# City of Albuquerque Stormwater Construction Site Inspection Report

Project Name and Location	Cleveland Middle School Track Comanche & Nadeau		
Site Contact Name & Agency	Richard Miller APS	Contact Phone #/ E-mail	
Date of Inspection	4-25-17	Start/End Time	11:25/11:30
Inspector Name, COA Dept.	Curtis Cherne, Stormwater Quality		
Inspector Phone / E-mail	505-924-3420/ccherne@cabq.gov		
Inspector Qualifications	Qualified Compliance Inspector of Stormwater- Stormwater One		
Describe Present Phase of Construction	Track paved

**From:** Cherne, Curtis  
**Sent:** Monday, April 10, 2017 8:07 AM  
**To:** Graeme Means (gmeans@highmesacg.com)  
**Subject:** Cleveland MS Track and Field grading  
**Attachments:** grading\_north\_area.jpg

DESIGNED BY	J.D.S.	NO.	DATE	BY	REVISIONS	JOB NO.	2016.180.3
DRAWN BY	J.Y.R./S.C.C.					DATE	02-2017
APPROVED BY	G.M.					SHEET	5 OF 9

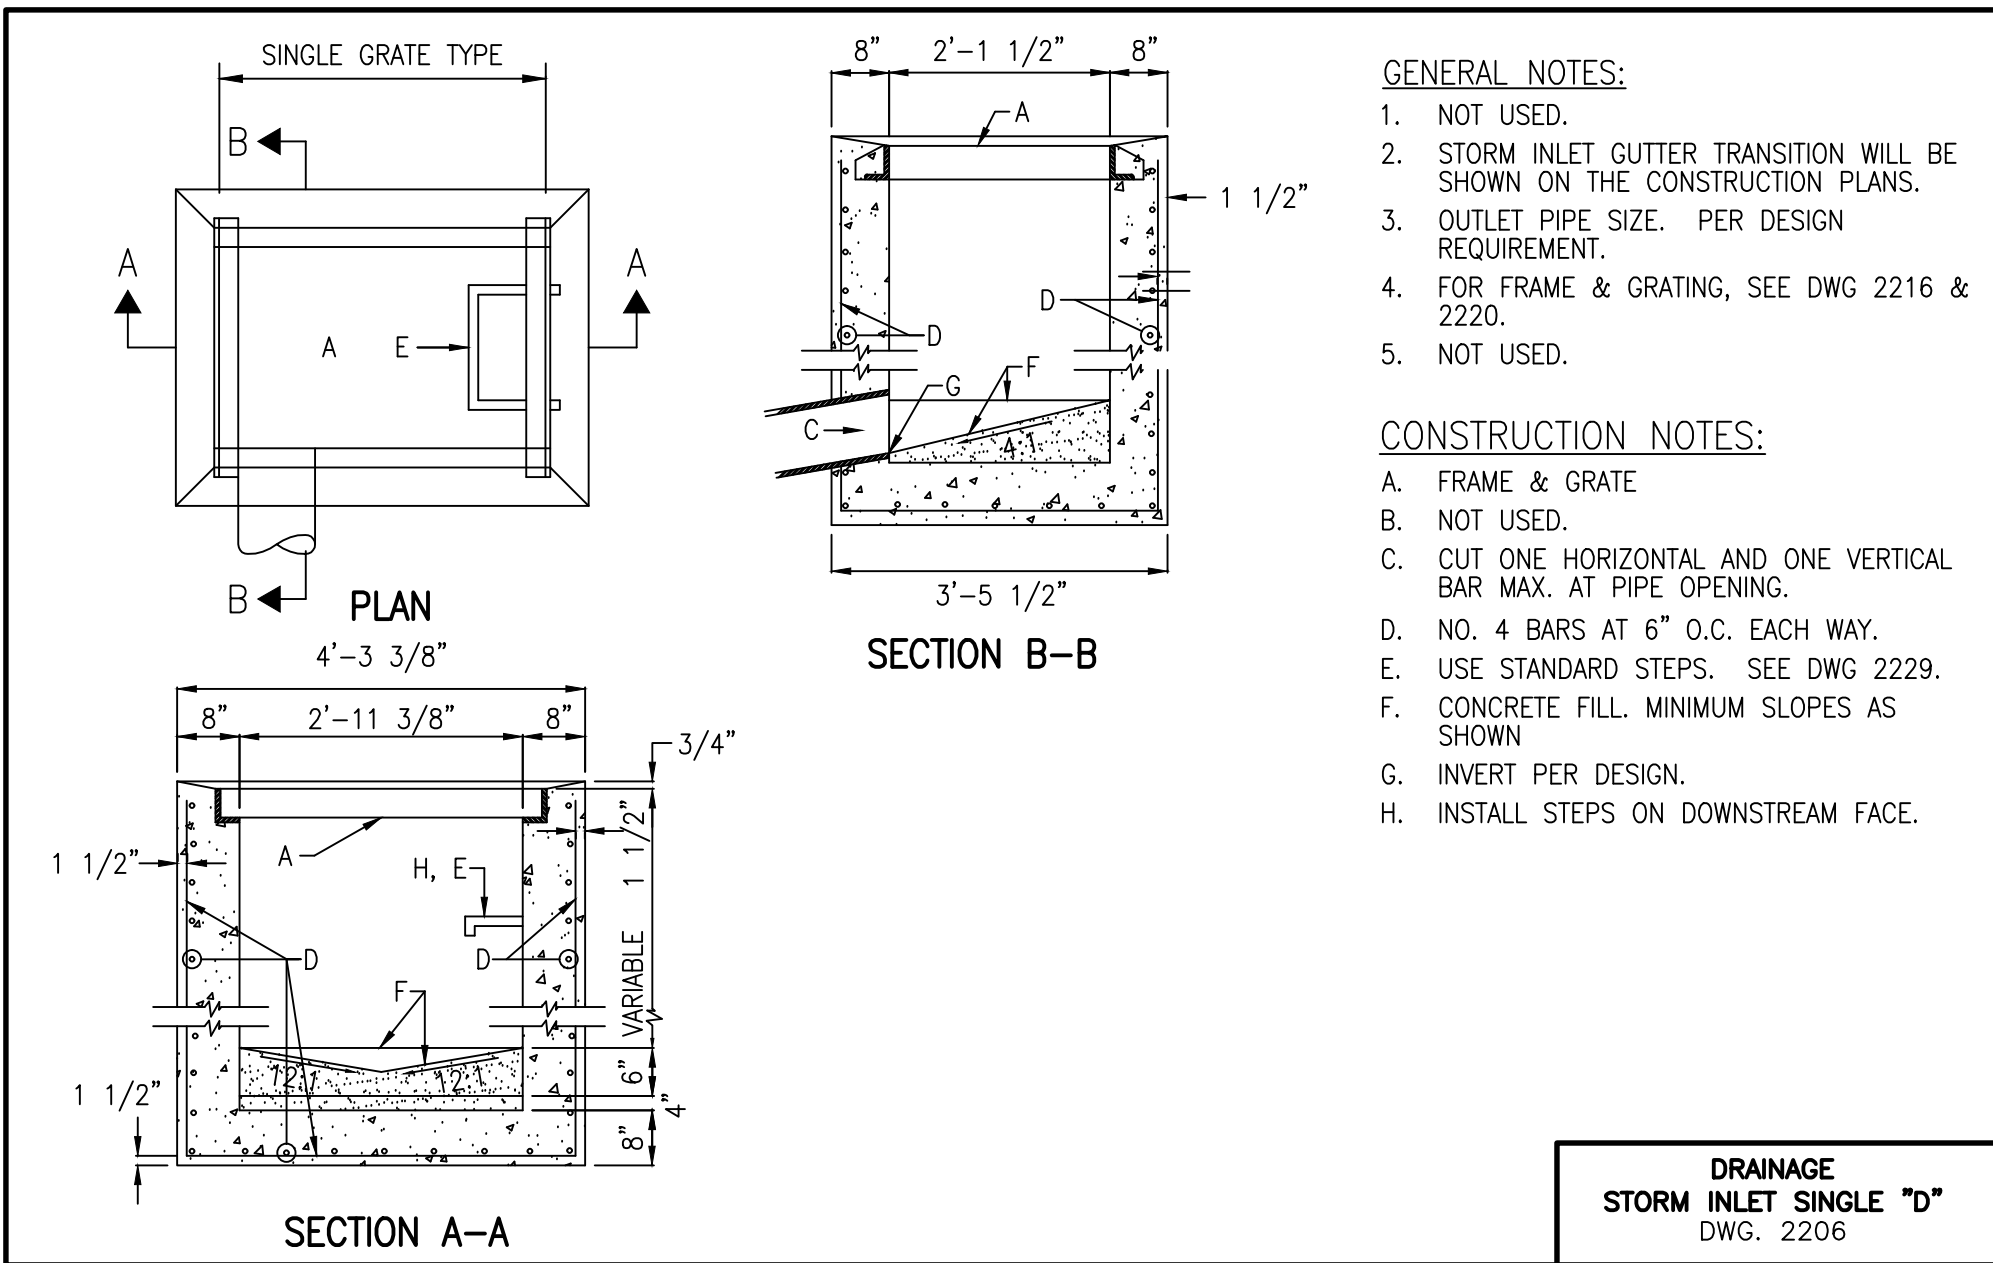
Altor was grading north of the basketball court (see attached photo).

I asked them why they were grading here as it is not shown on the plan and the supervisor told me that APS did not wish to export, but decided to spread-it-around.

I don't know if the change in grade adversely affects the drainage plan for the site, but I wanted to let you know.
